## Thomas FitzGerald - Online Submission from Martin Piper (object)

Site: #2109 Residential subdivision at Fraser Drive, Terranora  
[https://majorprojects.affinitylive.com/?action=view\\_site&id=2109](https://majorprojects.affinitylive.com/?action=view_site&id=2109)

**RE: 09\_0166 RESIDENTIAL SUBDIVISION FRASER DRIVE TERRANORA**

METRICON (QLD) PTY LTD
 ALTITUDE 1 - FRASER DRV. TERRANORA
 BUILDING PAD LAYOUT & SECTIONS
 Sheet 3 of 3

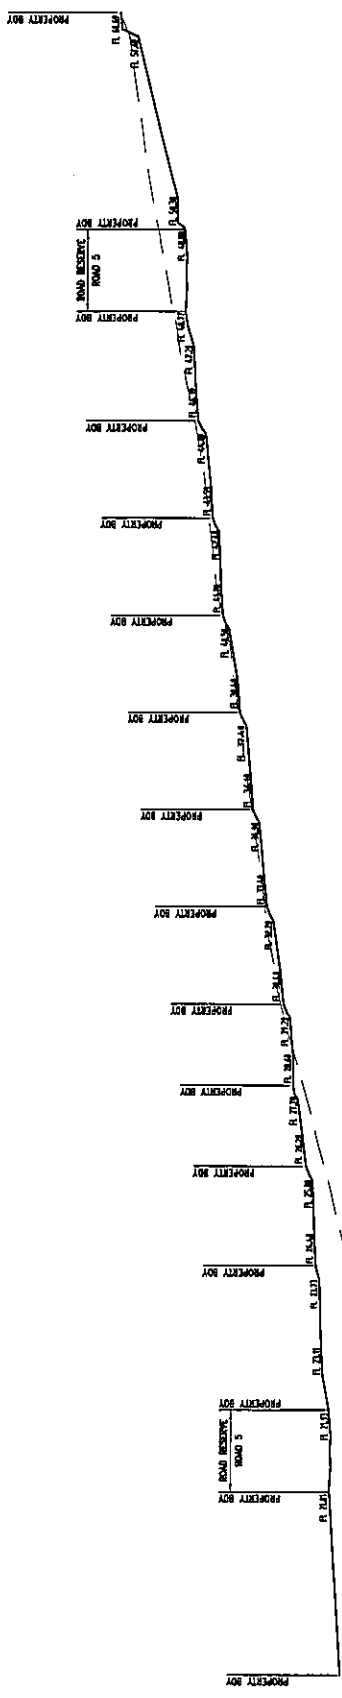
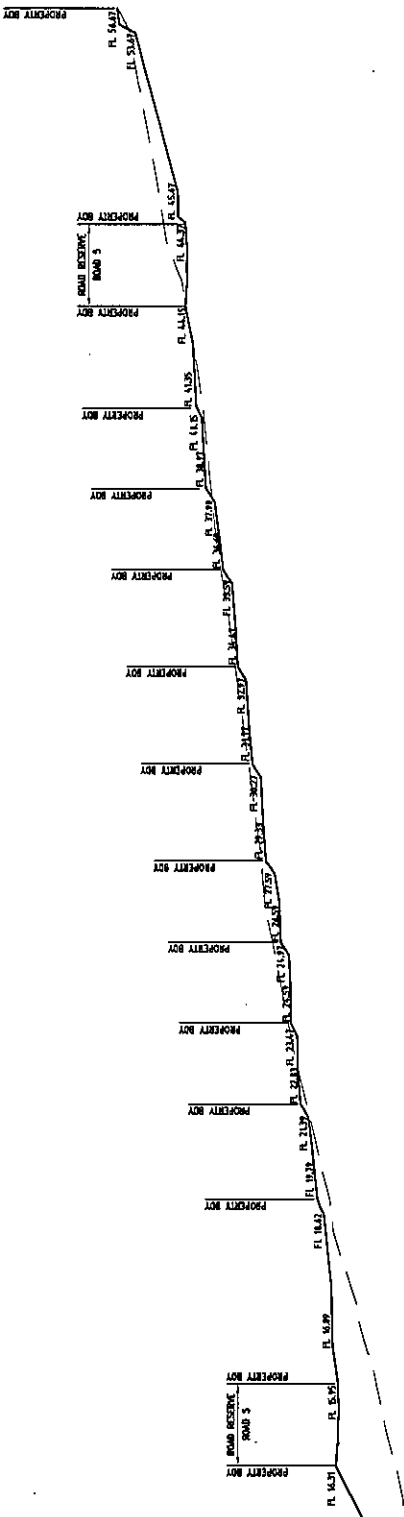
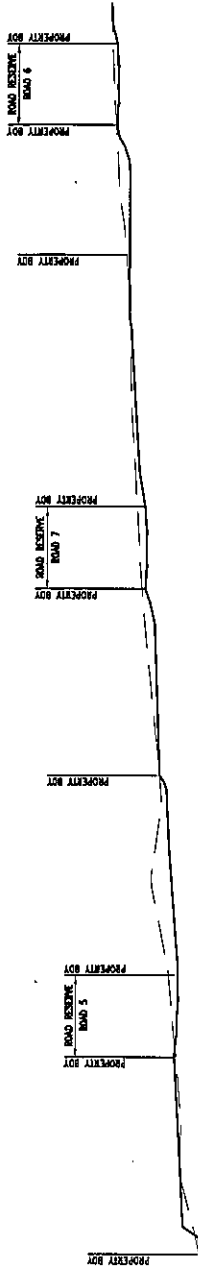
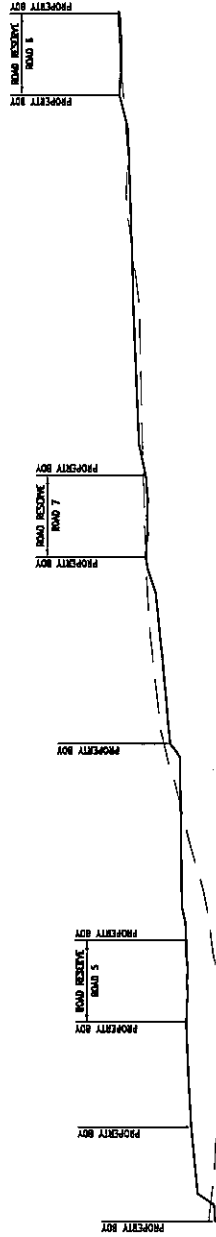
It is submitted that it does not appear that the report writer has given serious consideration to the scope of the proposed earthworks on this property. It is reported elsewhere that 18% of the property will be cut and filled. It is noted that there will be cuts of 5 to 6 metres in height in various areas.

In a recent discussion with a Developer's Representative, the writer and Mr Les Zahn, the owner of 26 Fraser Drive, were given assurances that there would be no cuts in the property in excess of 3 metres and that these would only be on the outside areas and that no blocks would have retaining walls in excess of 2 metres. As indicated earlier because of the various information being provided by the developer, it is not clear as to what the precise development proposal is. Either way it is in our view totally incomprehensible that the report writer would suggest that excavation to such an extent would not have a dramatic impact on the visual impact on the site.
